KITTITAS COUNTY  
BEFORE THE HEARING EXAMINER

SEPA Appeal of Conditional Use Permit Application of: Cascade Field and Stream Club	CU: CU-11-00003
---	-----------------

Memorandum of Appellant with Respect to SEPA Appeal

CASCADE FIELD AND STREAM POSSIBLE FUTURE RANGES

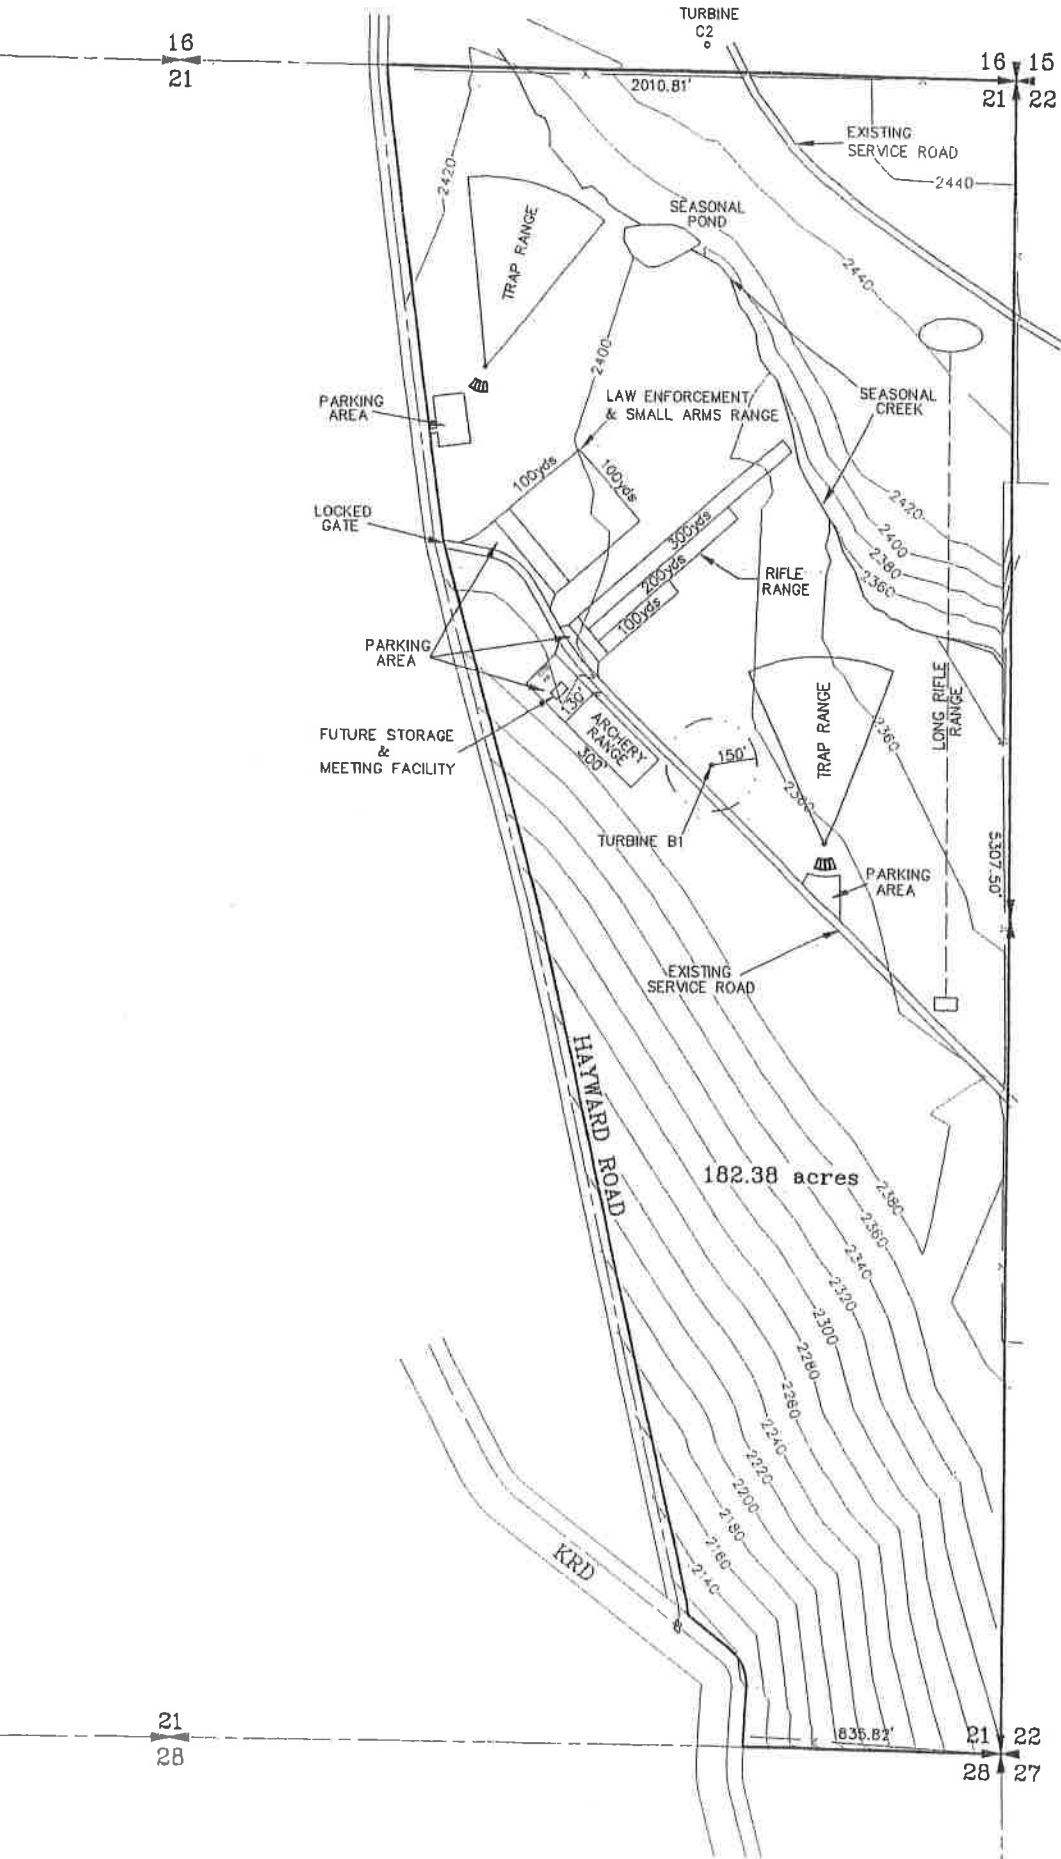
8 Cascade Field & Stream Club described the project proposal as "... Shooting Range  
9 on 182 acre site as per Attachment A with future use as per Attachment B." (Exhibit 2).  
10 Attachment A is a topographic depiction of the "existing conditions" on the parcel with no  
11 specific site plan. Attachment B contains "possible future ranges" but does not identify any  
12 specific development timelines or procedures. The reviewing agencies and commenting  
13 public were left to speculate with respect to timing, development and integration of the multi-  
14 faceted facility. The nature and scope of usage is vague.

(Exhibit 55 at 2). Attachment B presents a wide range of facilities and improvements. The  
problem is that there is no way to determine what is to be built at any given time. The  
project proposal sets the locations, components and activities that are to be evaluated in the

1 environmental review process.<sup>3</sup> No information is provided, however, with regard to timing  
2 or integration of project improvements (e.g. parking, roads, ranges, etc.). And the attachment  
3 provides no specific information (e.g. berm location, sound baffles, excavation, target pits,  
4 lead management, etc.). All that is said is that the ranges will be constructed in accordance  
5 with Attachment F. Does this mean that range backstops, side berms, graded roads, concrete  
6 shooting slabs, trap houses and other features will all be installed prior to operation? There is  
7 simply no way to understand the sequence of phasing of the proposal. Applicant provides the  
8 following summary of phased development:

24 (Exhibit 55). Will parking lots, water and sanitary facilities, road access and other features  
25 be constructed at the outset and prior to any range construction? What “range specific”  
26 improvements will apply to each specific facility? It is simply impossible to understand the  
27 scheduling and timing of improvements. And in the absence of a reasonable schedule, it is  
28 impossible to identify and implement appropriate mitigation measures.

17 Checklist A.7. Simply reflects that "... [a]dditional range is similar to Attachment F.  
18 Range designs may be added in the future." Those range designs include shooting range  
19 definitive drawings prepared by National Rifle Association. Those standards should apply  
20 immediately to the project and be constructed prior to any use of the property. The  
21 references also inaccurate because "possible future ranges" are identified in Attachment B.  
22 No timing or design standards are established for the identified "... possible future ranges."

NOISE MEASUREMENT STATIONS FROM TABLE 1-ATTACHMENT E

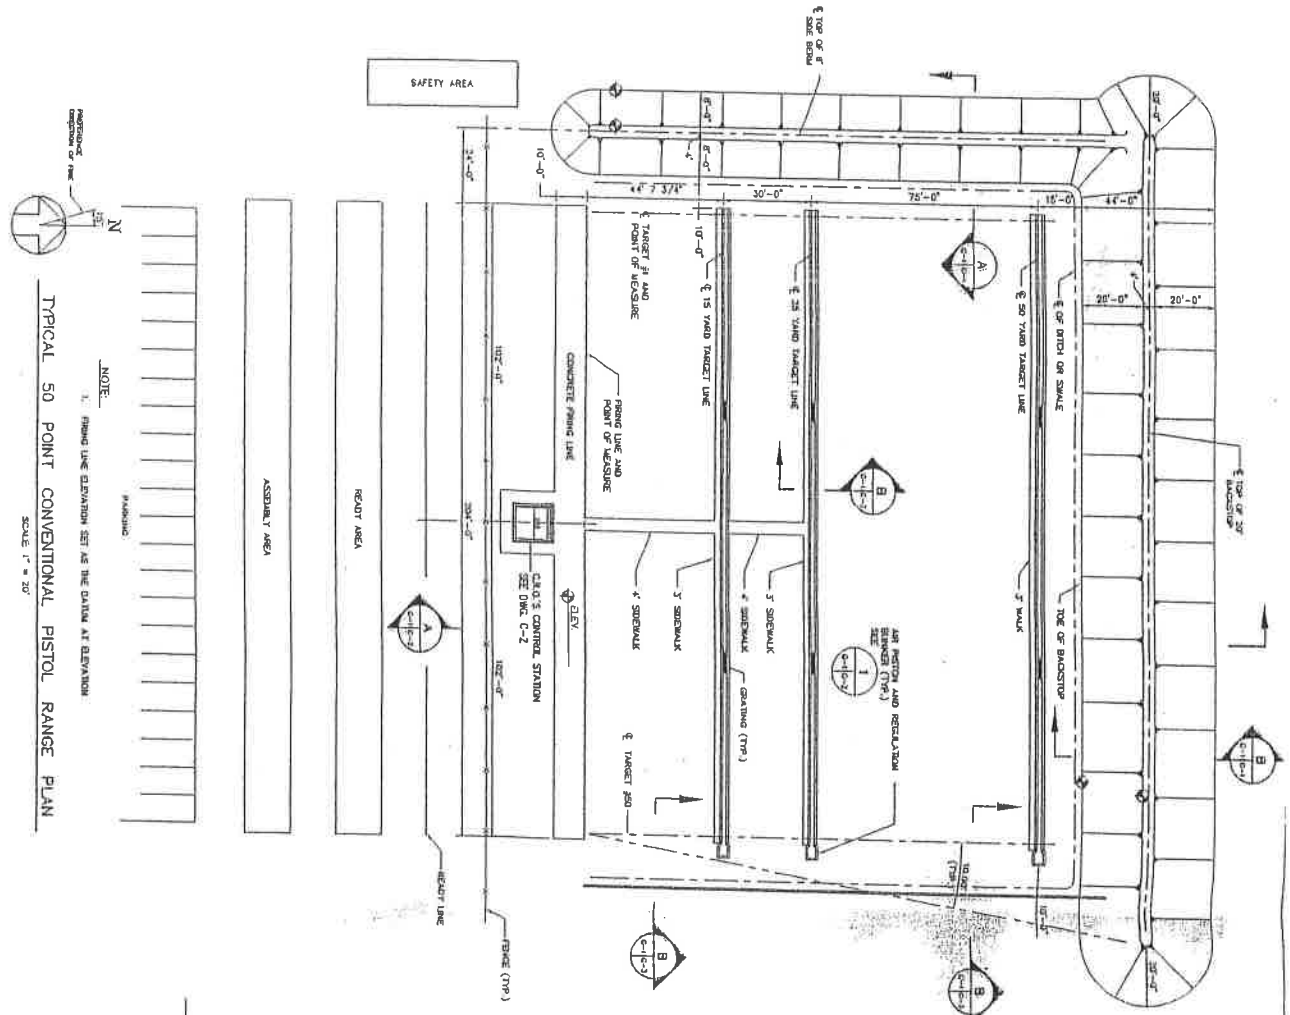
6 (Exhibit 2 Attachment E-5). Piacsek acknowledges report deficiencies and Applicant has  
7 taken no steps to correct the deficiencies. Appellants provided expert comment on the  
8 original noise report as prepared by JGL Acoustics, Inc., and dated December 13, 2003  
9 (Exhibit 50). Acoustic expert Jerry G. Lilly, P.E., F.A.S.A.<sup>6</sup> identified specific errors,  
10 inconsistencies and defects in the report and concluded:

11           3.       Piacsek incorrectly identifies the receiving property as Class CEDNA. WAC  
12 173-60-030. Receiving property should be classified as Class AEDNA (lands where human  
13 beings reside and sleep).

14           4.       Piacsek's report establishes violation of applicable noise standards. Table I  
15 shows peak sound pressure levels measured at nearby residential properties as high as 81dBA  
16 at Location 12 and 79dBA at Location 14.
